Application no: H03-0876-11

Description: Two storey side extension and single storey rear extension to dwelling

Location: 8 Campains Lane
Deeping St Nicholas
Spalding
Lincs
PE11 3EX
PE11 3EX

Amendment: Roof line lowered (dwg. no. 2072-03A)

Drawing Number	Revision
a1	2072-03
	A

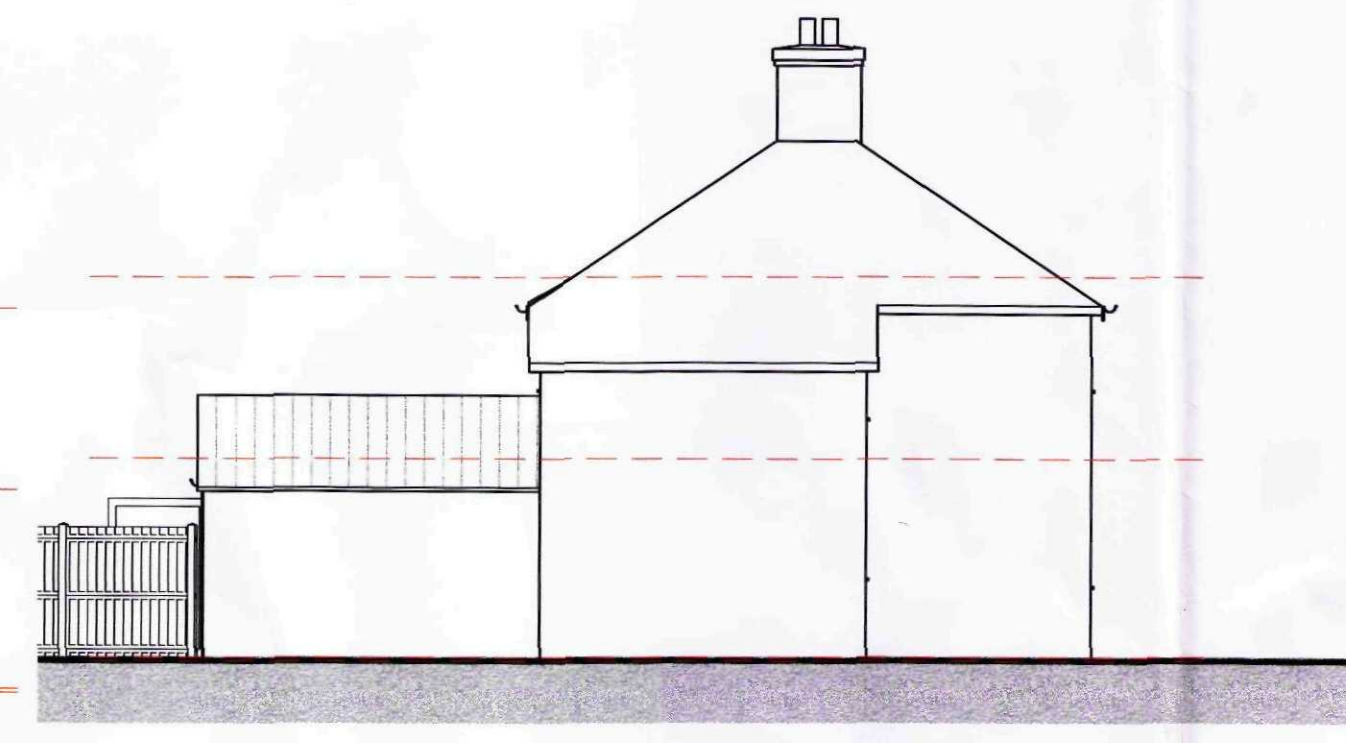
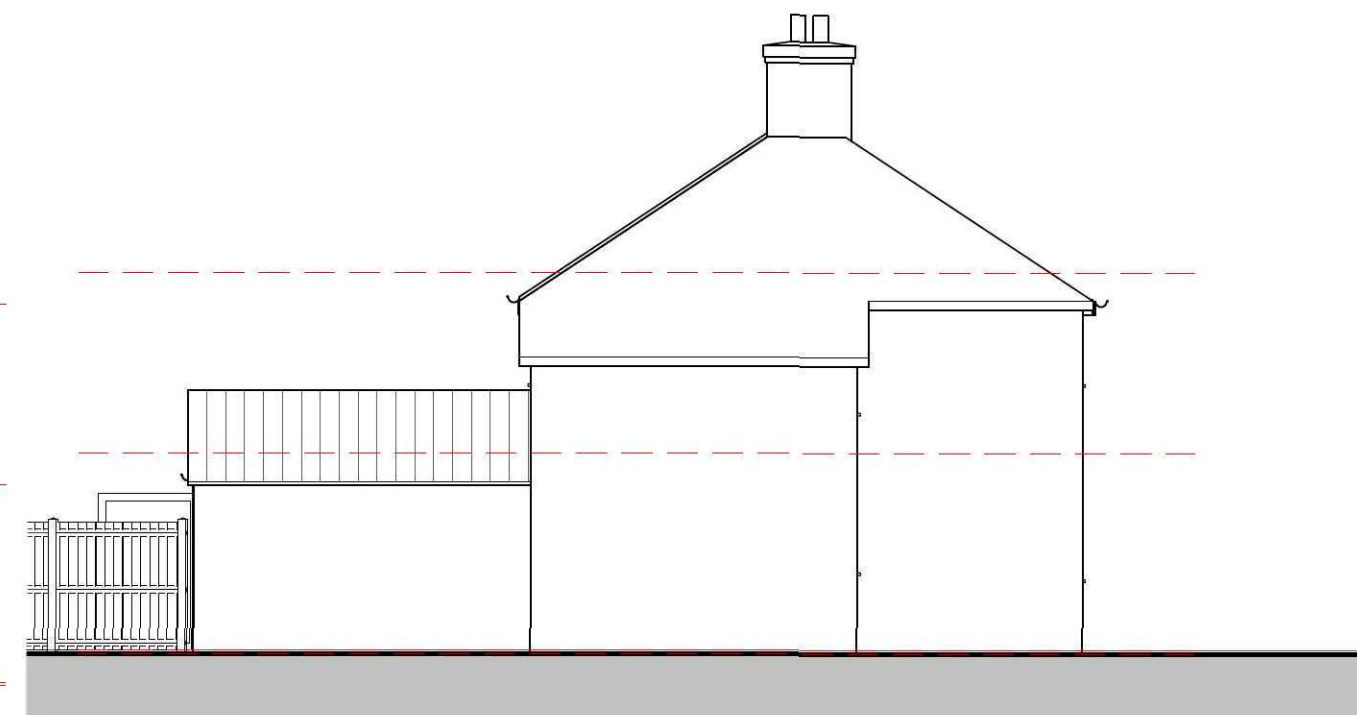
The Parish Council has objected to the roof line of the proposed extension and the neighbour from No.7 has raised concern with regard to the party wall and the angle of the roof of the proposed single storey extension.

It would be preferable if the ridge line of the extension was lowered so that it was no higher than the existing house. I presume there will be a party wall agreement in relation to the adjoining property.

Amended drawing showing roof line lowered as requested.
